**KIRKLEES METROPOLITAN COUNCIL
INVESTMENT & REGENERATION SERVICE**

Reference No:	2025/62/92199/E
Site Address:	70, Barnsley Road, Upper Cumberworth, Huddersfield, HD8 8NN
Description:	Erection of single storey rear extension
Recommending Officer:	Faiza Bano

HOUSEHOLDER DELEGATED REPORT

Client: Mr & Mrs Doyle
Project: 70 Barnsley Road, Upper Cumberworth, Huddersfield
Drawing: Scheme As Proposed

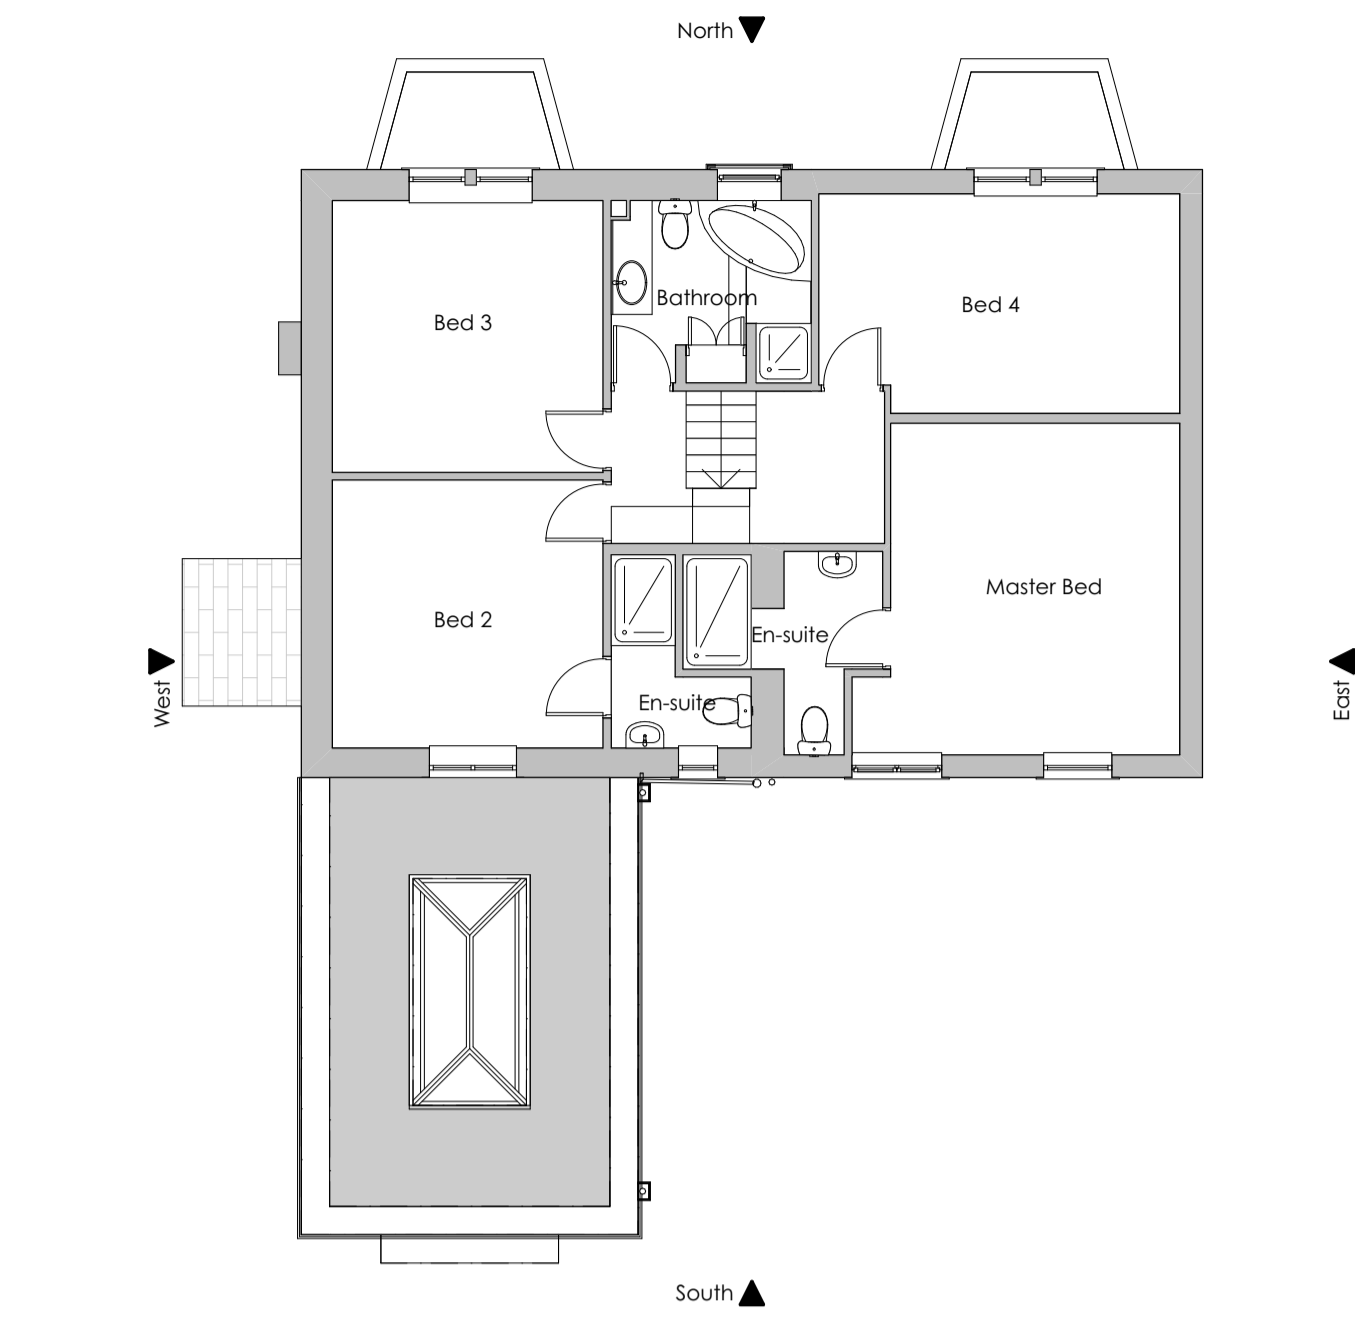
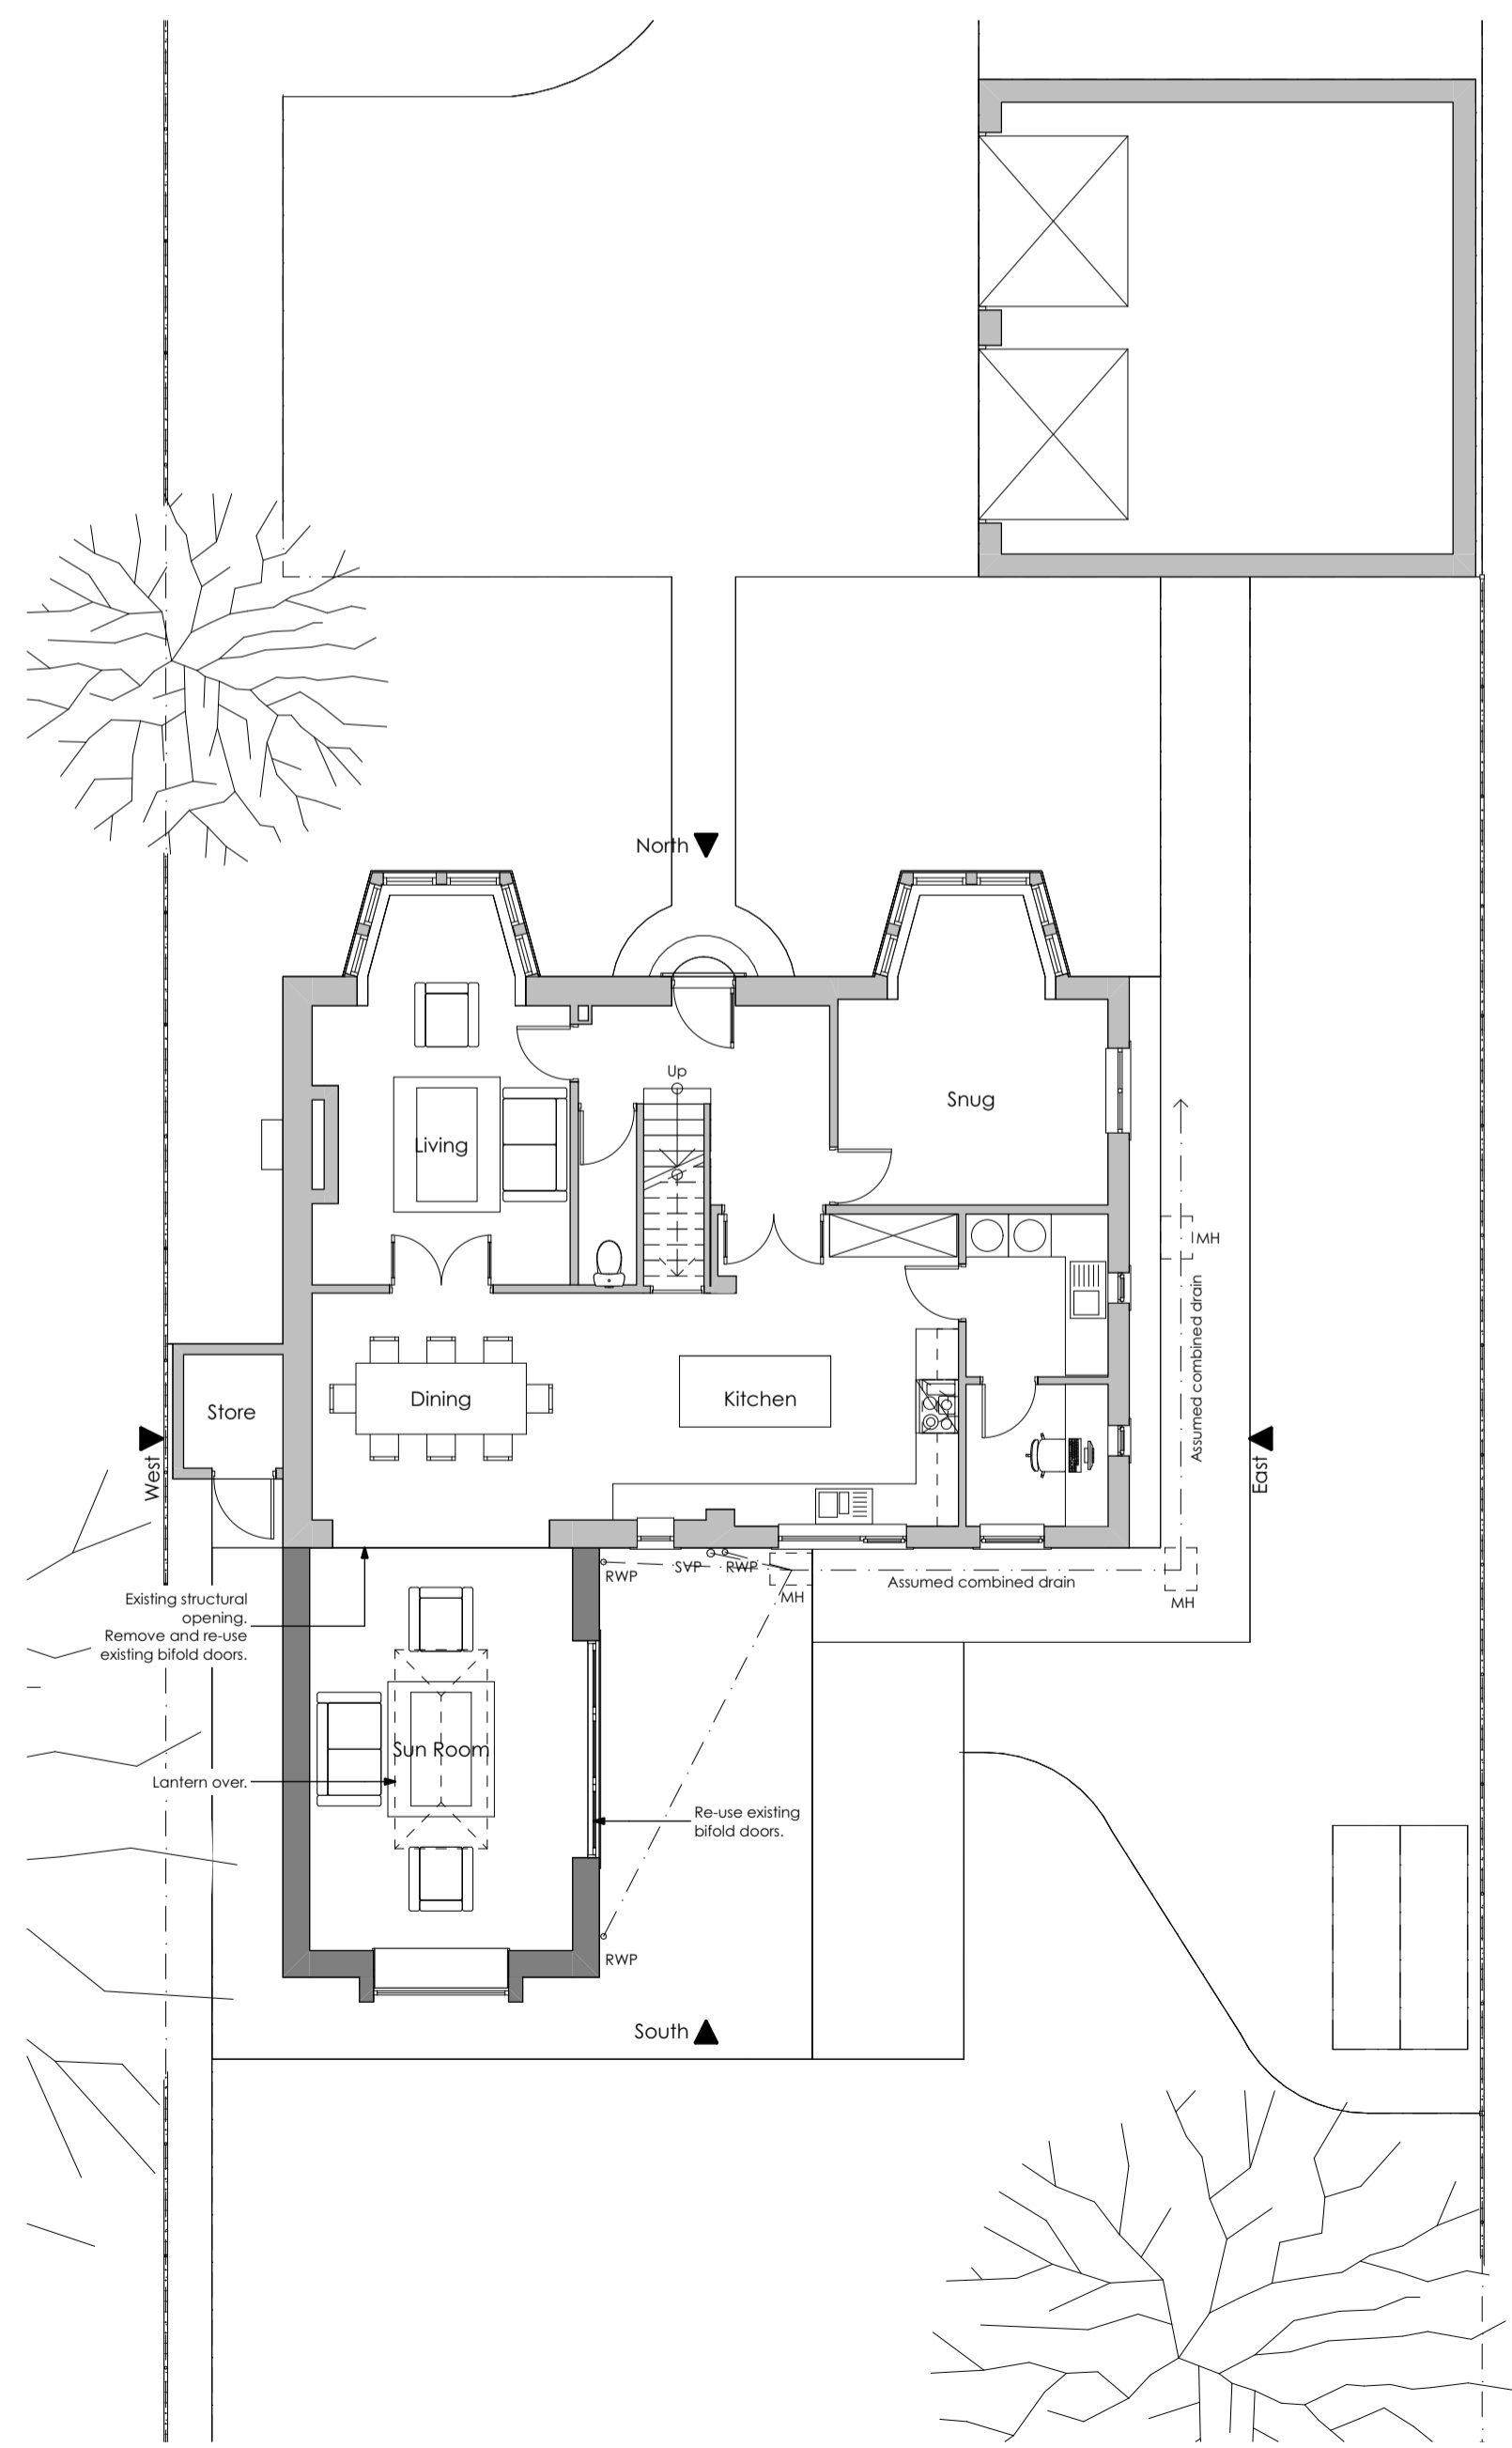
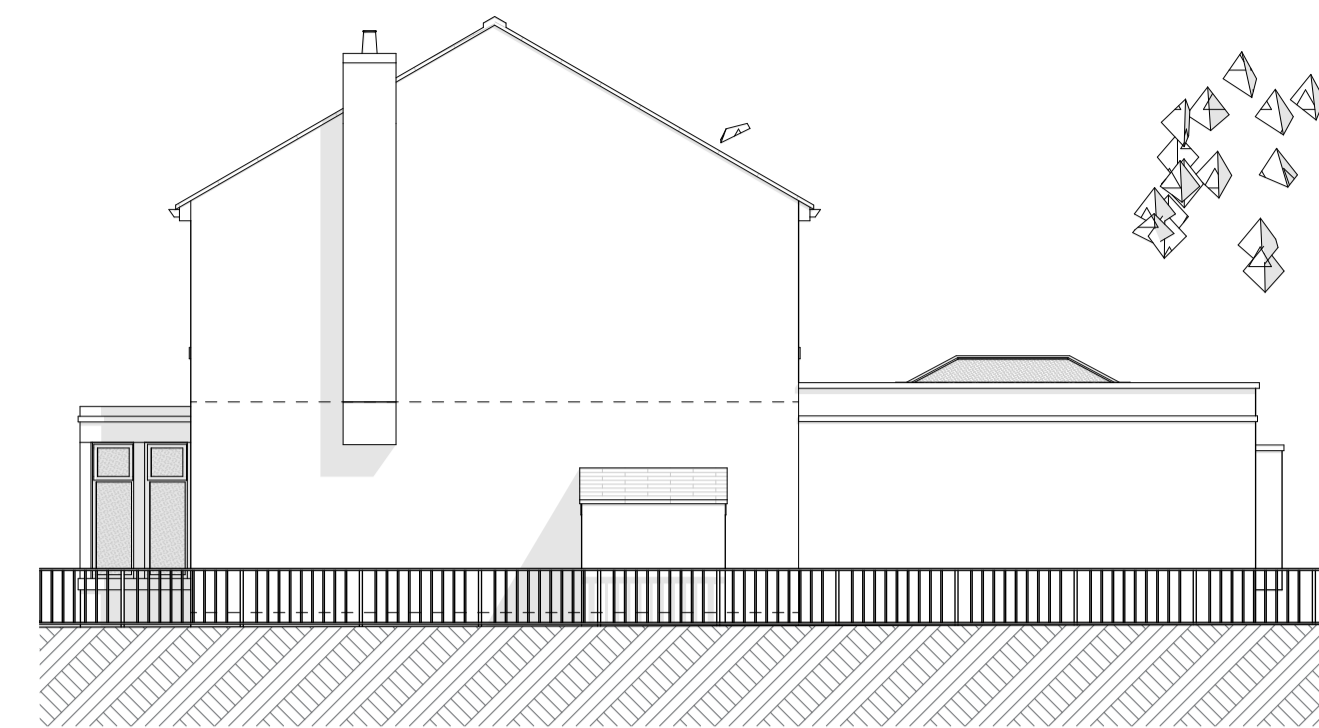
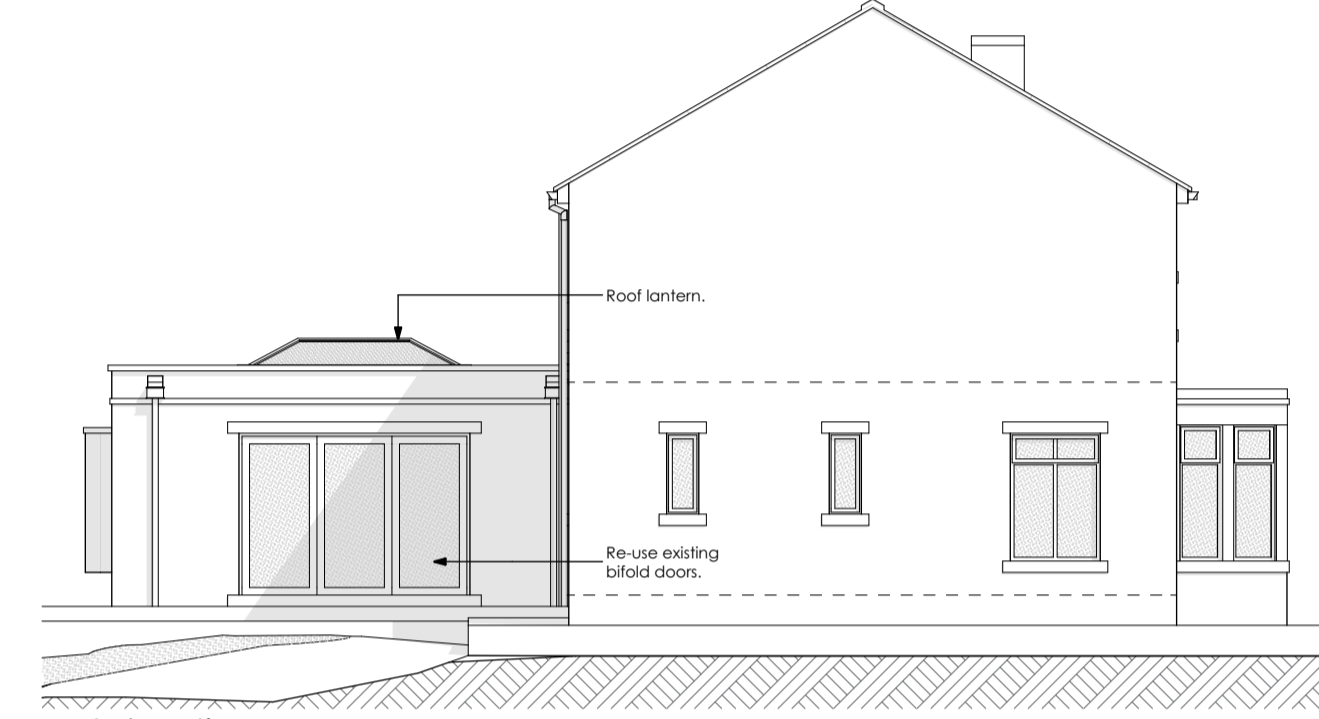
not project out more than 3 metres from the rear wall of the original house for semi-detached and terraces houses or by 4 metres for detached properties;		No – The extension projects 6.4 metres from the original rear elevation and spans a width of 4 metres. Despite its depth, the modest height and single-storey nature of the

proposal help to mitigate any potential overbearing impact on neighbouring properties. Given the scale of the development in relation to the host dwelling, the separation distance from the shared boundary, large curtilage of the neighbouring property, the proposal is not considered to result in significant harm to residential amenity. The extension is therefore deemed acceptable.
where they exceed 3m in length the eaves height should generally not exceed 2.5 meters; and	Yes – the extension is flat roofed and has an overall height of 3.4 metres, which includes the roof lantern.	
retain a gap of at least 1 metre from a property boundary, such as a wall, fence or hedge.	Yes – the extension retains over a 1 metre gap.

Facing materials and detailing	<ul style="list-style-type: none"> • KDP 9 of the SPD • Policy LP24 Design (d) (iii) of the KLP • Chapter 12 of the NPPF 	Facing materials to match existing.	✓
Roof style	<ul style="list-style-type: none"> • KDP 1 and 2 of the SPD • Policy LP24 Design (a), (c) and (d) of the KLP • Chapter 12 of the NPPF 	Flat roof style – acceptable as applicants could build something similar in size and scale under permitted development.	✓
Window proportions	<ul style="list-style-type: none"> • KDP 1 and 2 of the SPD • Policy LP24 Design (a), (c) 	Modest size windows in rear extension, with floor to ceiling windows and sky lights, which would	✓

3. The external walling material of the extension hereby approved shall in all respects match that used in the construction of the existing building.

4. The extension hereby approved shall be constructed utilising a pile and beam foundation.

Block Plan - Proposed
1:250

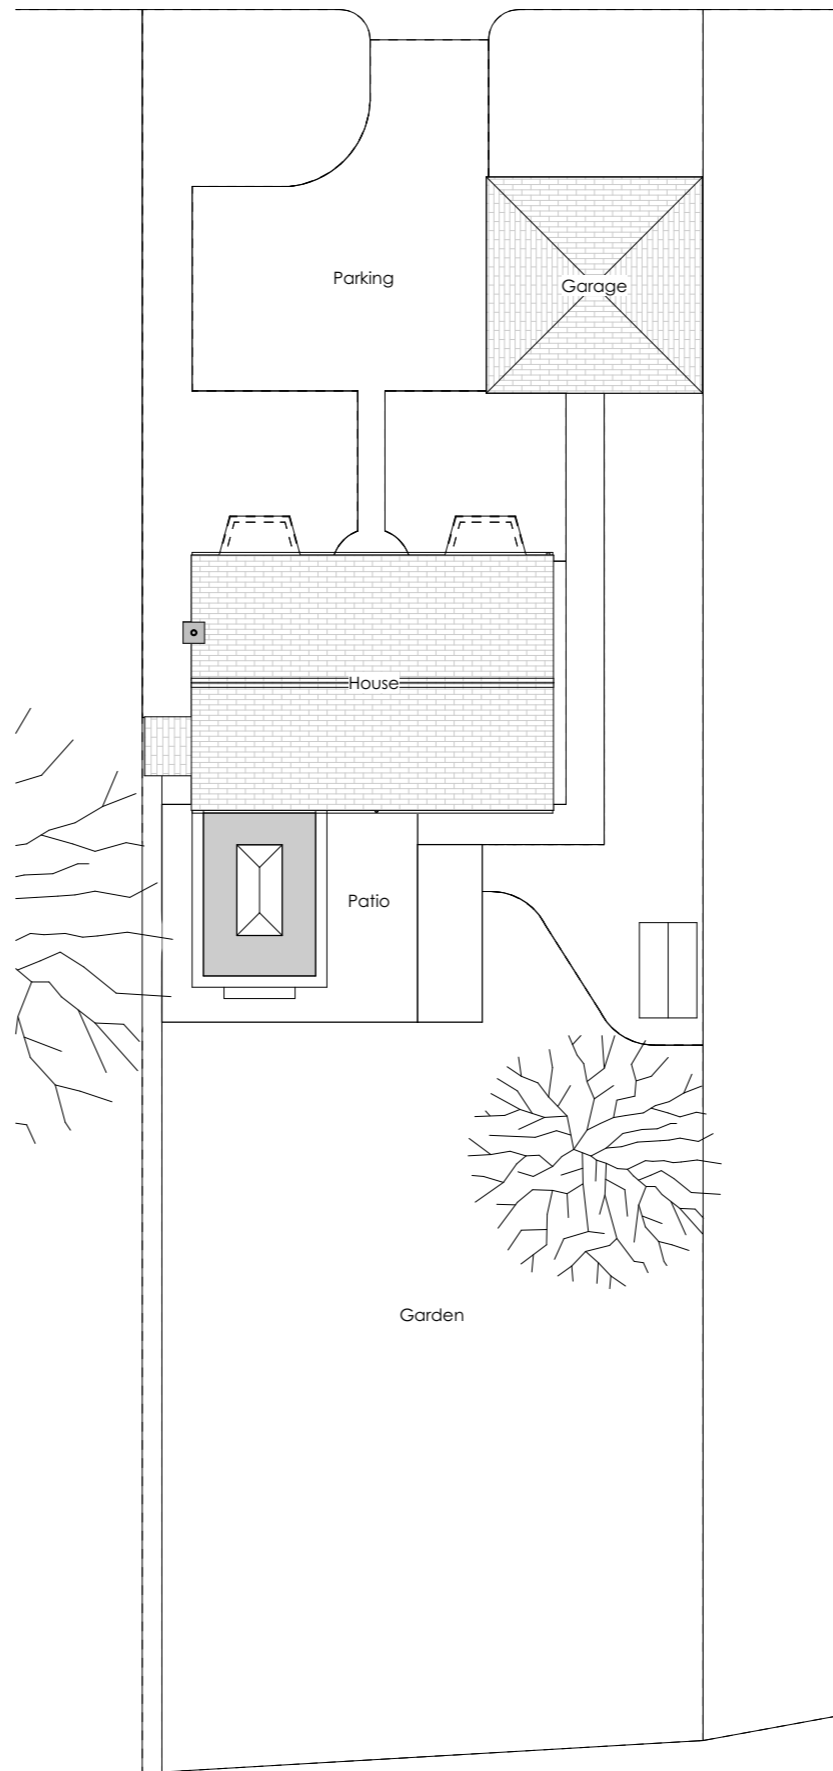
- 68 Barnsley Road - there is over a metre distance between the shared boundary of these properties, and it is considered that there will be little to no impact on this dwelling for the reasons set out above.
- 4 Dearnfield – The rear of this property is located to the front of the application site. There will be no impact on this dwelling given that the proposed development is located to the rear of the application site.
- There are no properties located to the rear.

Relevant key design principle (KDP) of the SPD, Policy in the Kirklees Local Plan and the NPPF	Further comments	✓ / X / N/A
Impact on trees	<ul style="list-style-type: none"> KDP 13 of the SPD Policy LP24 Design (d) (i) (iv) Policy LP33 Trees Chapter 12 of the NPPF 	There is a tree on the shared boundary with No.68 which overhangs the boundary. Given the projection of the proposal, there is potential for it to impact upon the root system of the tree. Informal consultation has been undertaken with the Council's Trees officer who advised that in the absence of an Arboricultural Impact Assessment, it would be reasonable to impose a condition requiring installation of a pile and beam foundation. The agent has confirmed their acceptance of such a condition, which would ensure that the development accords with Policy LP33 of the KLP.	✓
Impact on ecology	<ul style="list-style-type: none"> KDP 12 of the SPD Policy LP30 Chapter 15 of the NPPF 	N/A	✓
